Our Ref: LU/333/19/NMA

Non material amendment following the grant of LU/201/16/RES as amended by LU/43/19/PL for plot boundary changes, minor alterations to elevations of houses & flats.

Windroos Nursery & Land Adjoining Worthing Road Littlehampton BN17 6LY

| TITLE   | 2 BEDROOM FLATS - FLOOR PLANS |        |                 |

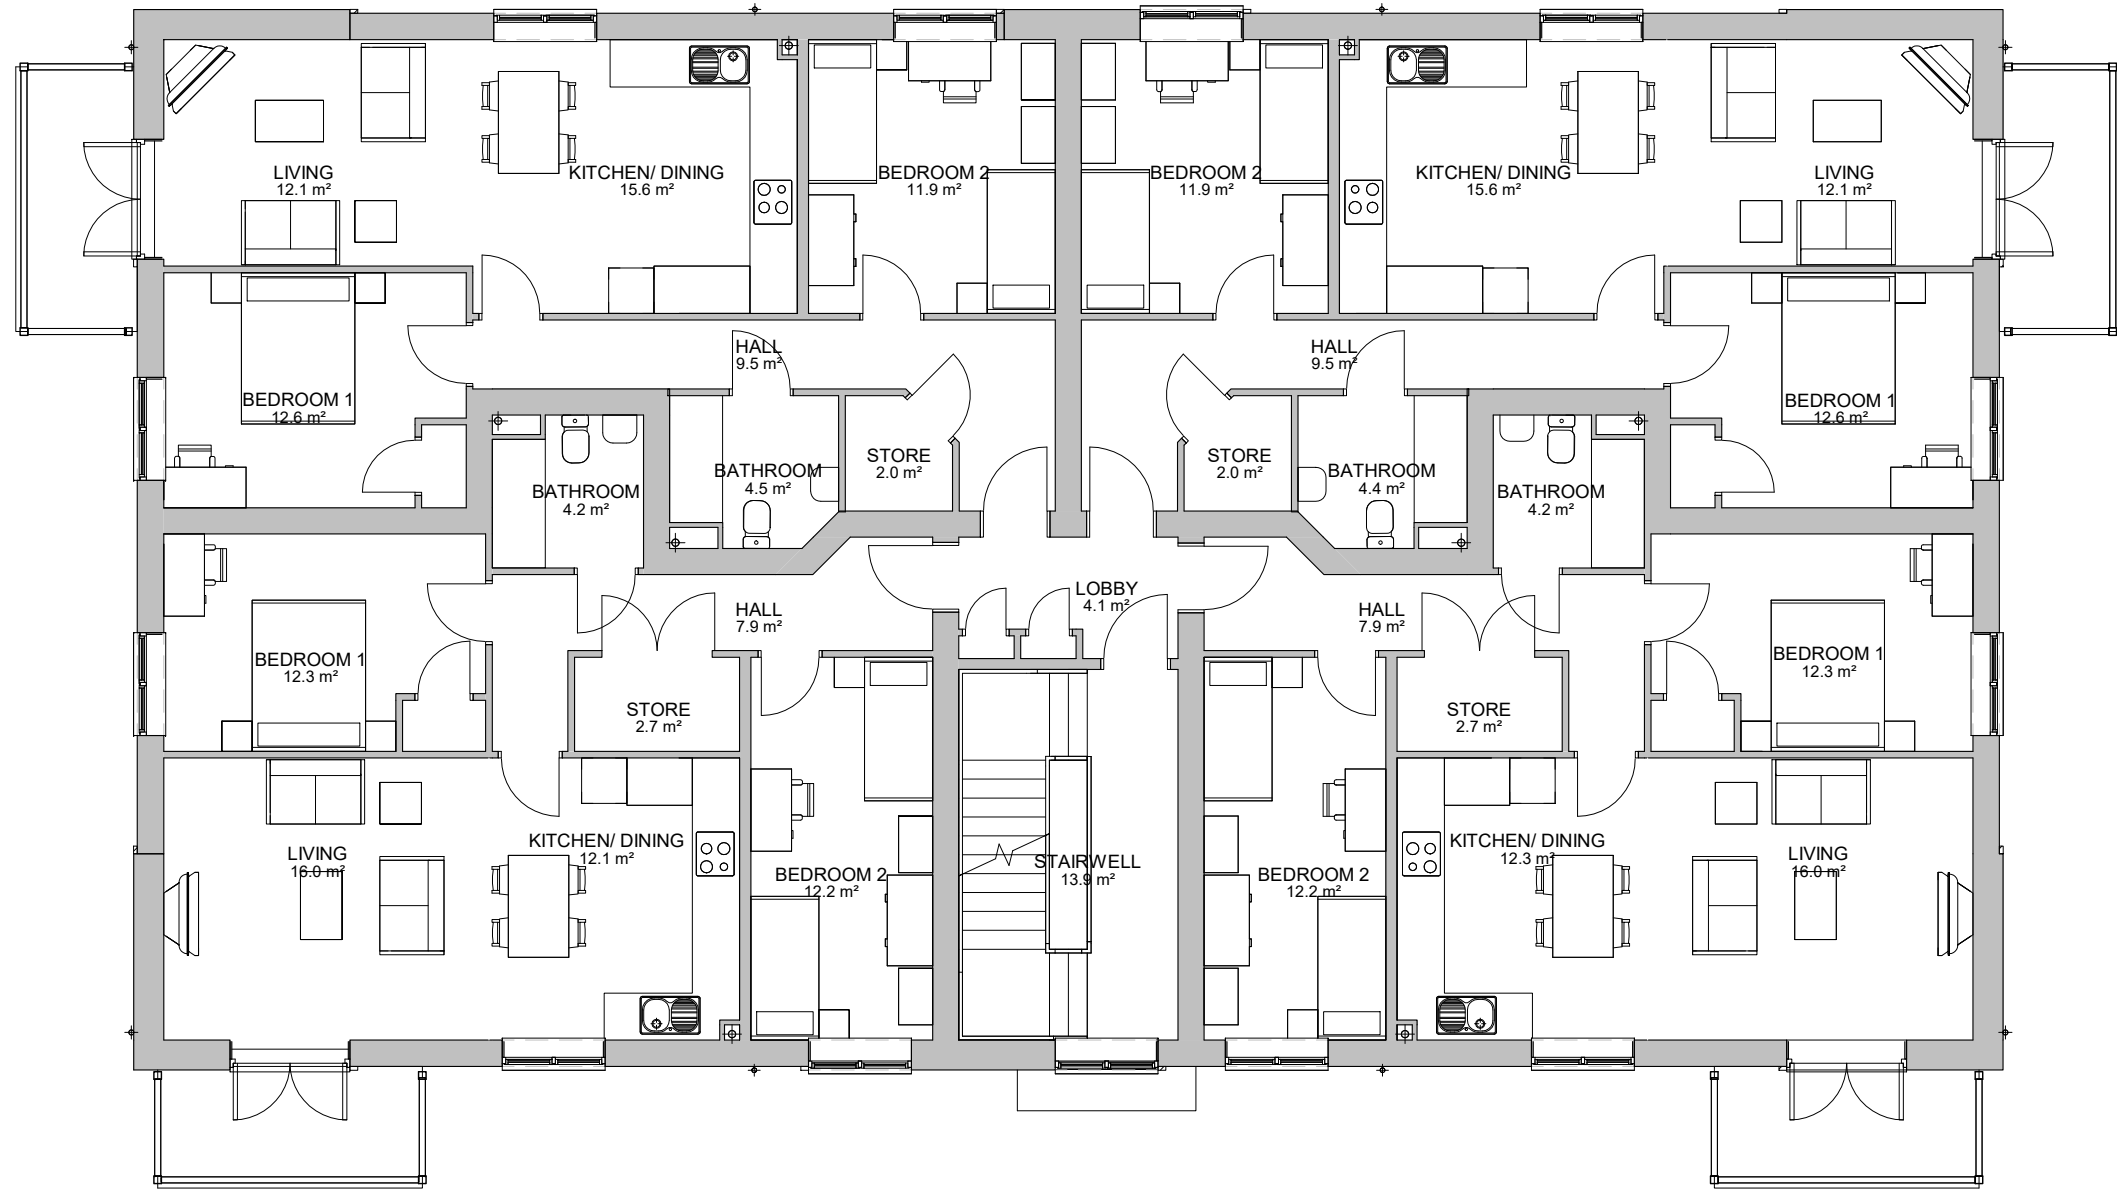
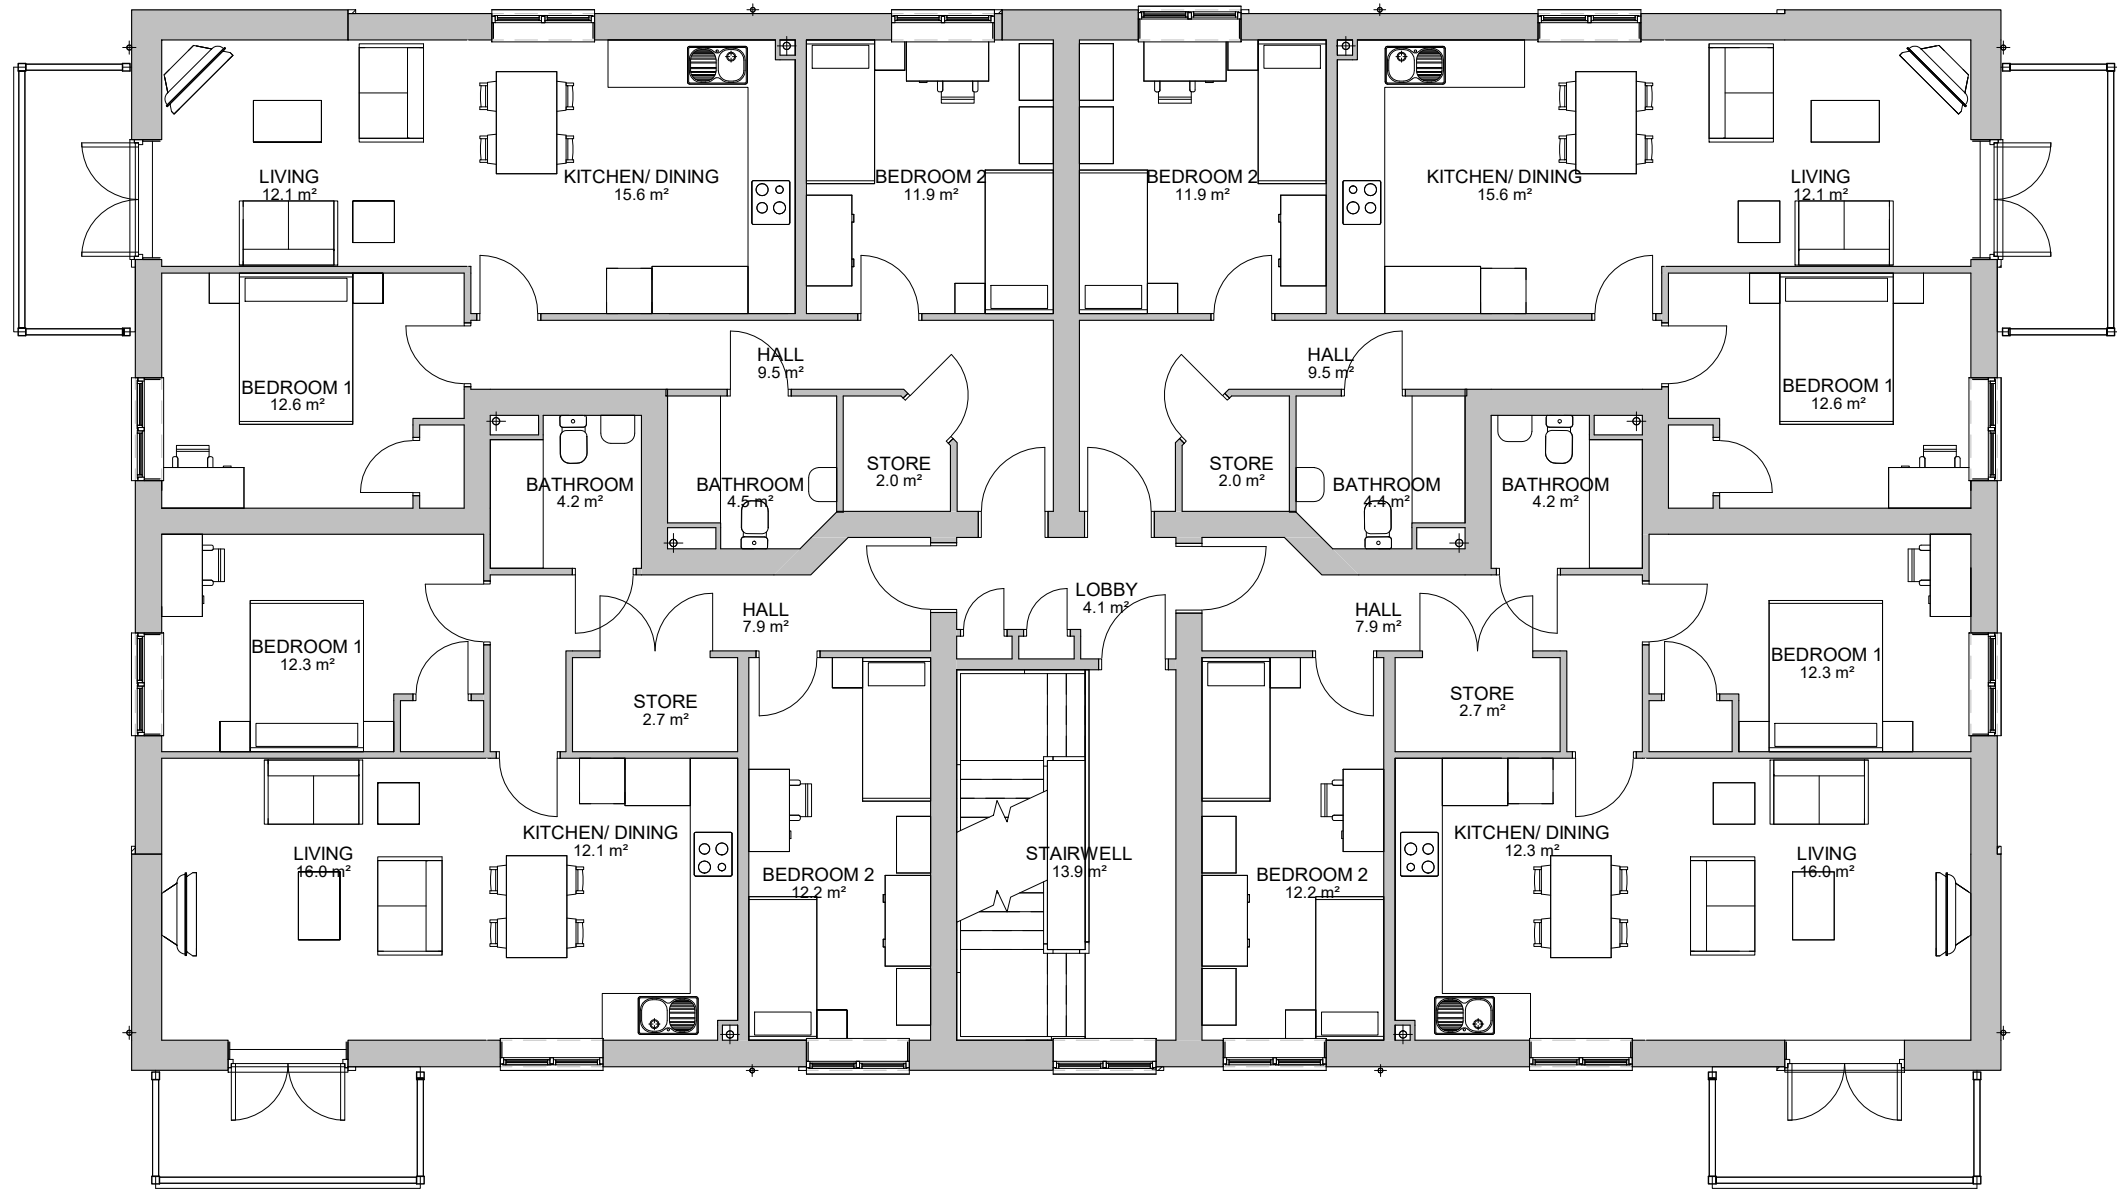
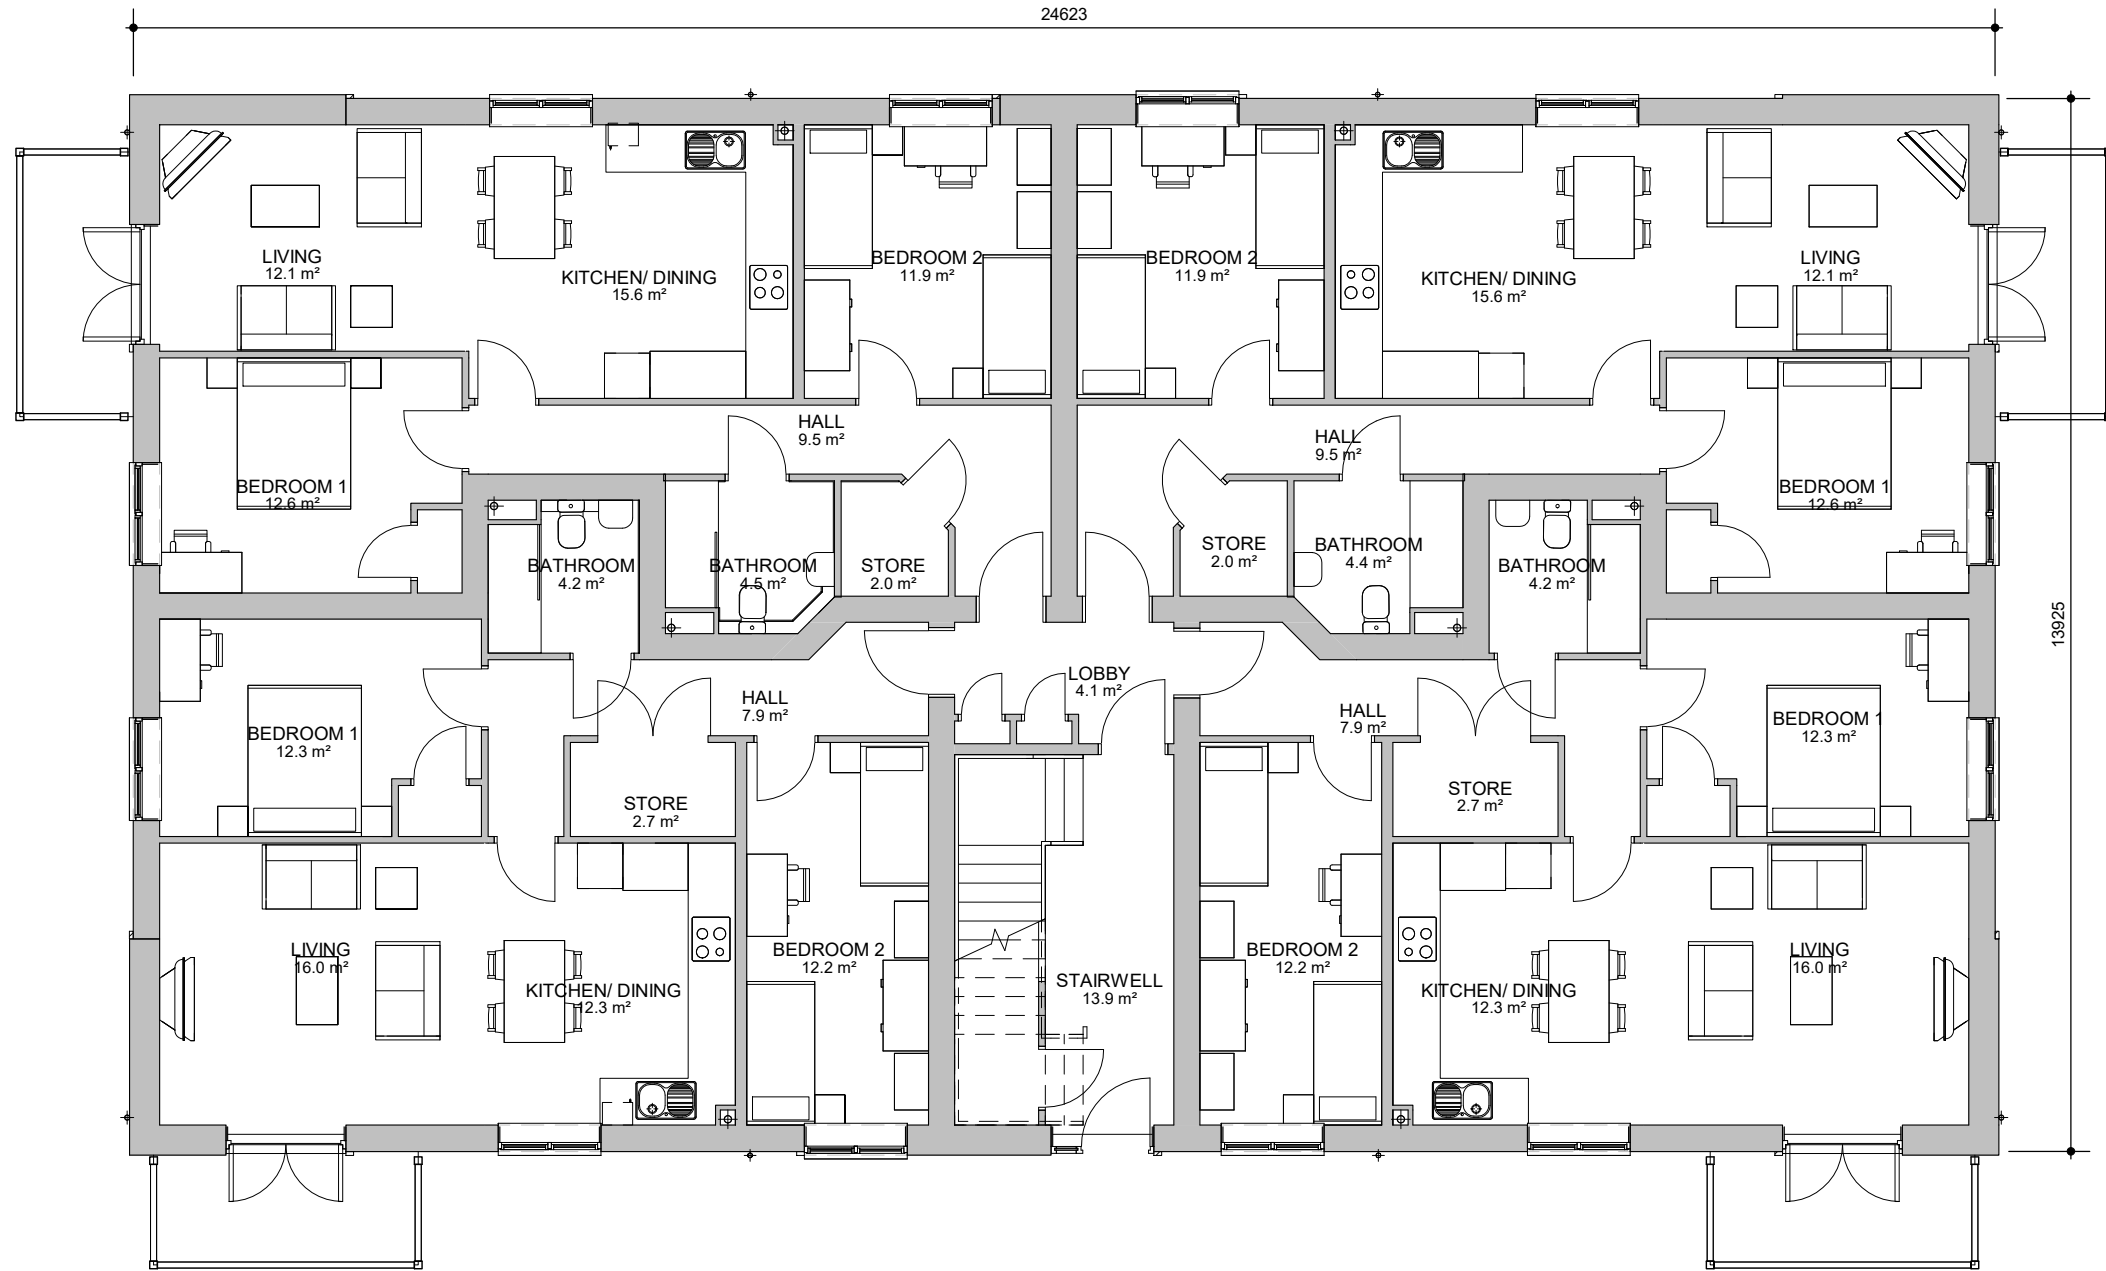
2 BEDROOM FLATS PLAN & ELEVATIONS

- Corbells added.
- Balcony Glazing amended to remove solid panel.
- Curtain walling/glazing to landing replaced with full height windows with infill cladding.

TITLE PROPOSED SITE PLAN - SHEET 2 OF 2

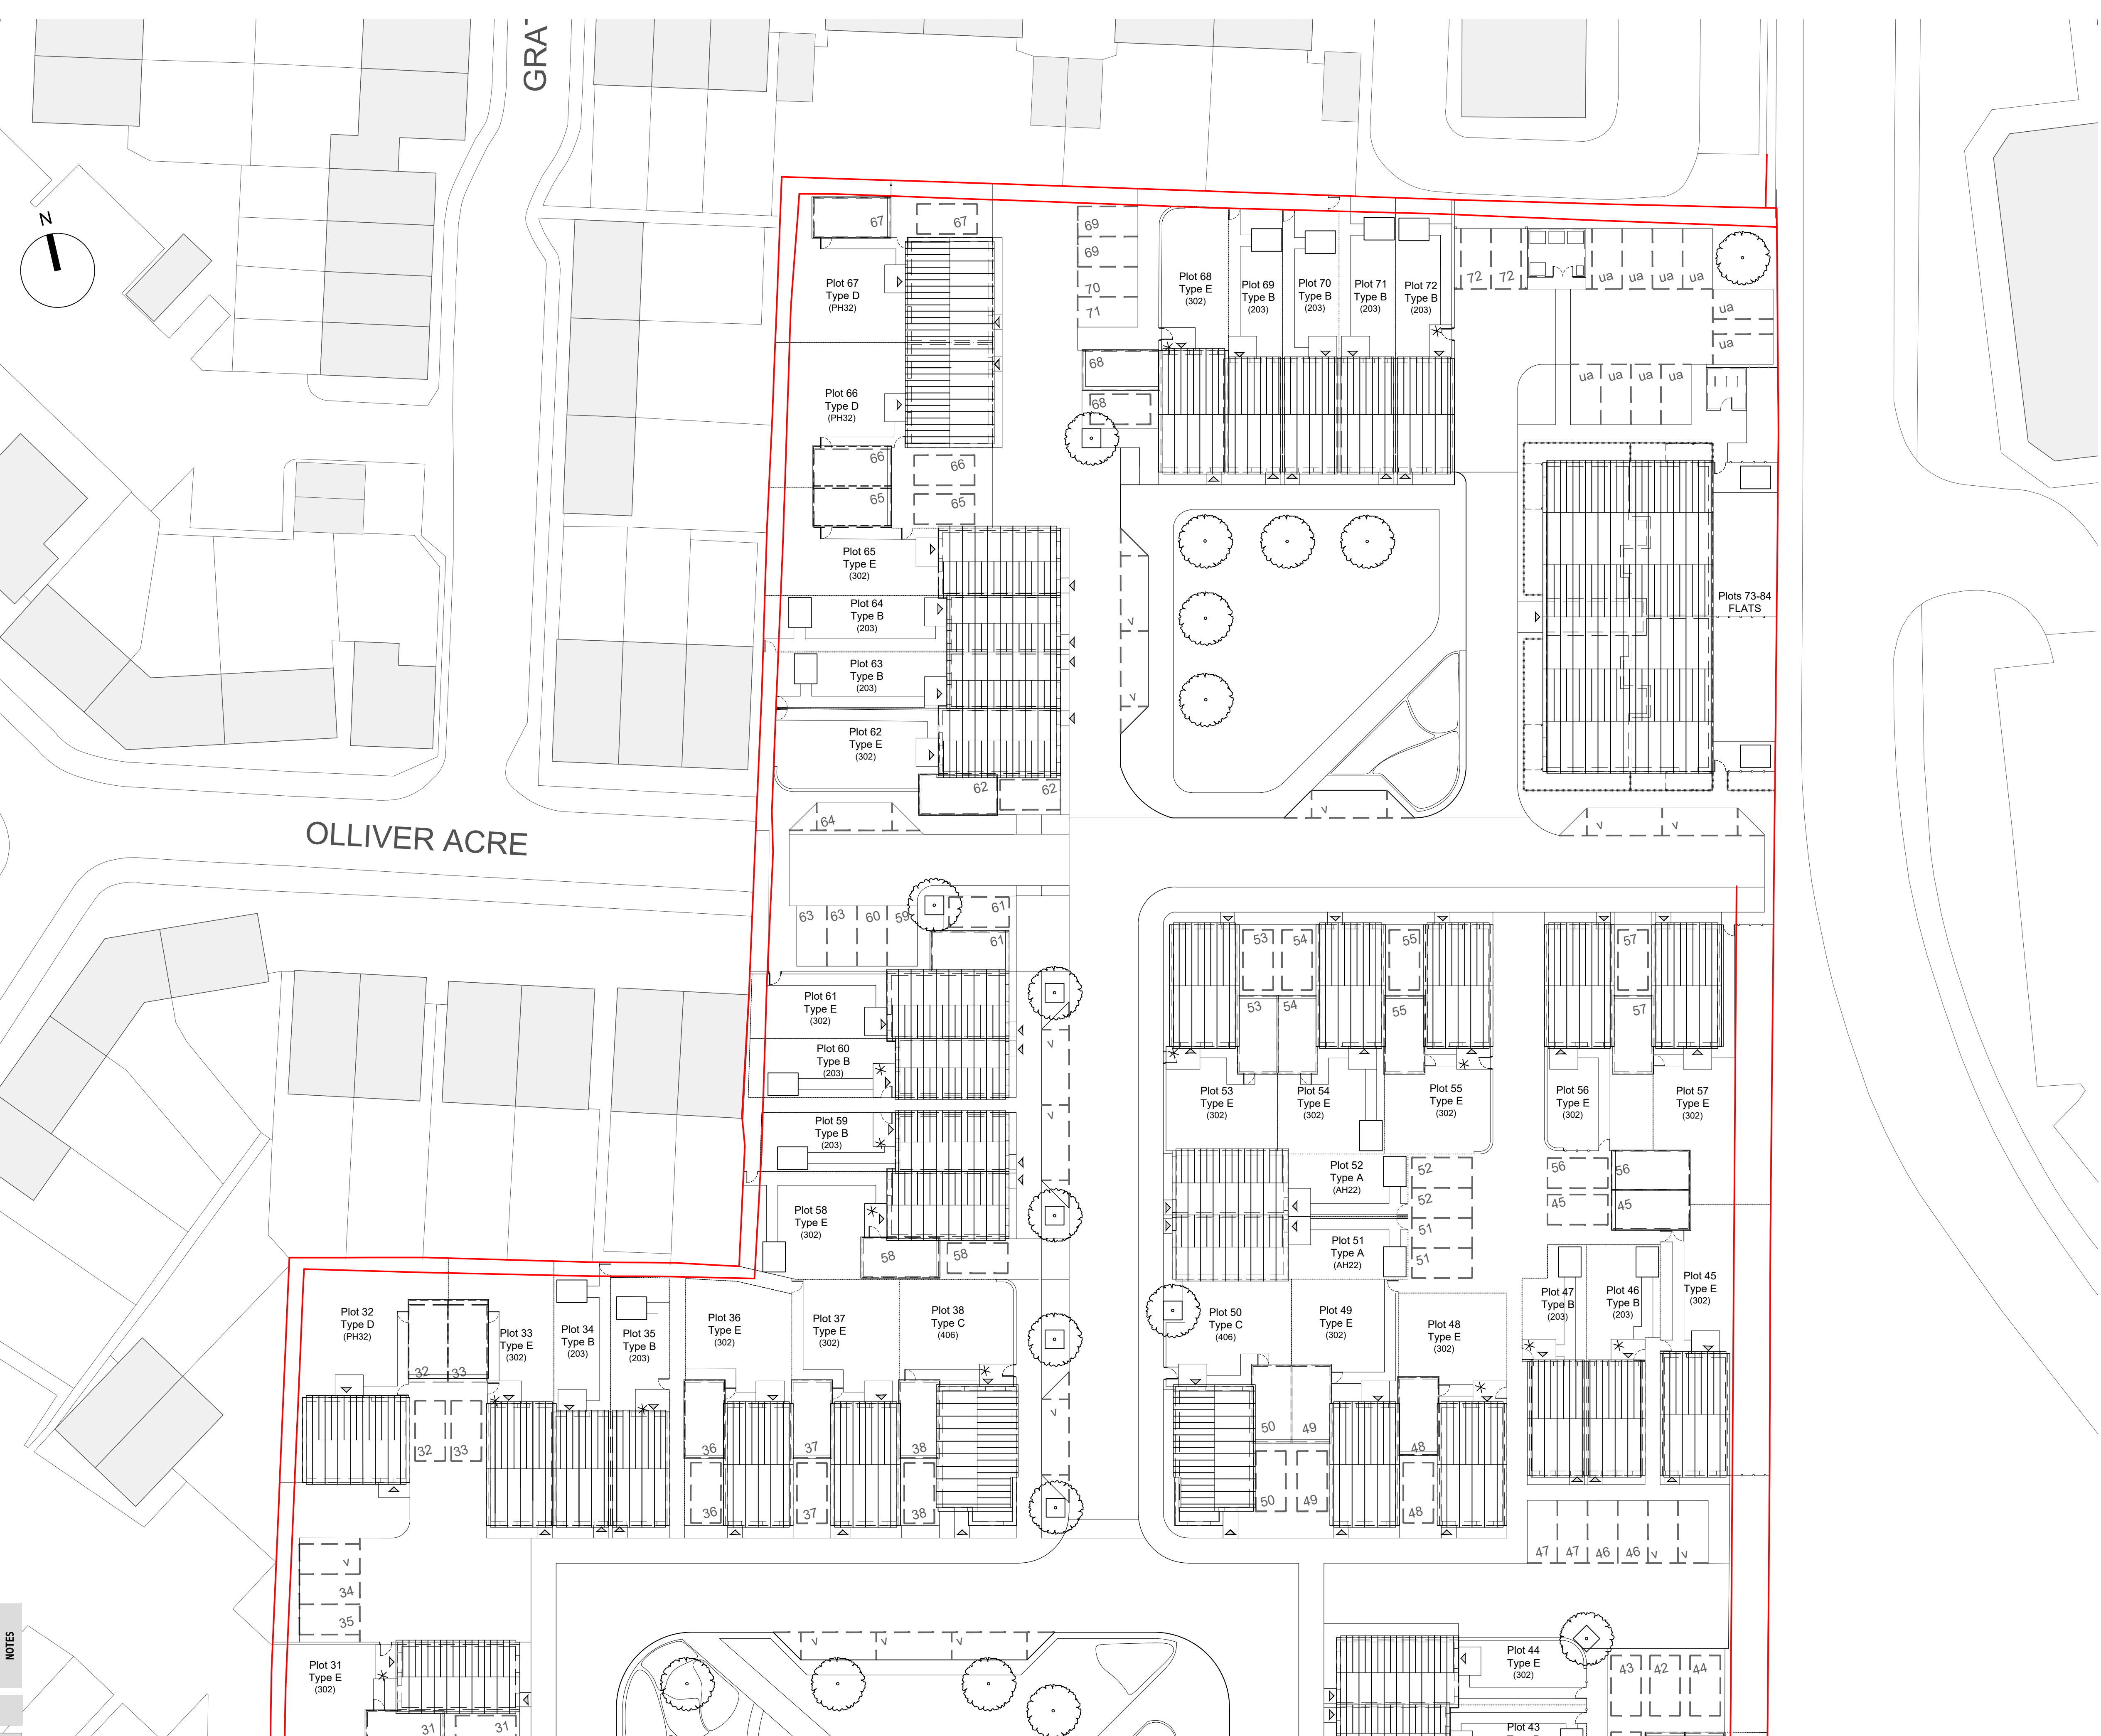
SITE PLAN:

- A former right of way on the east boundary and a former ransom strip to west and northern boundaries included into the plot boundaries.
- Rear access paths provided.
- Parking spaces to plots 5,6,7,8 & 41 re-aligned.
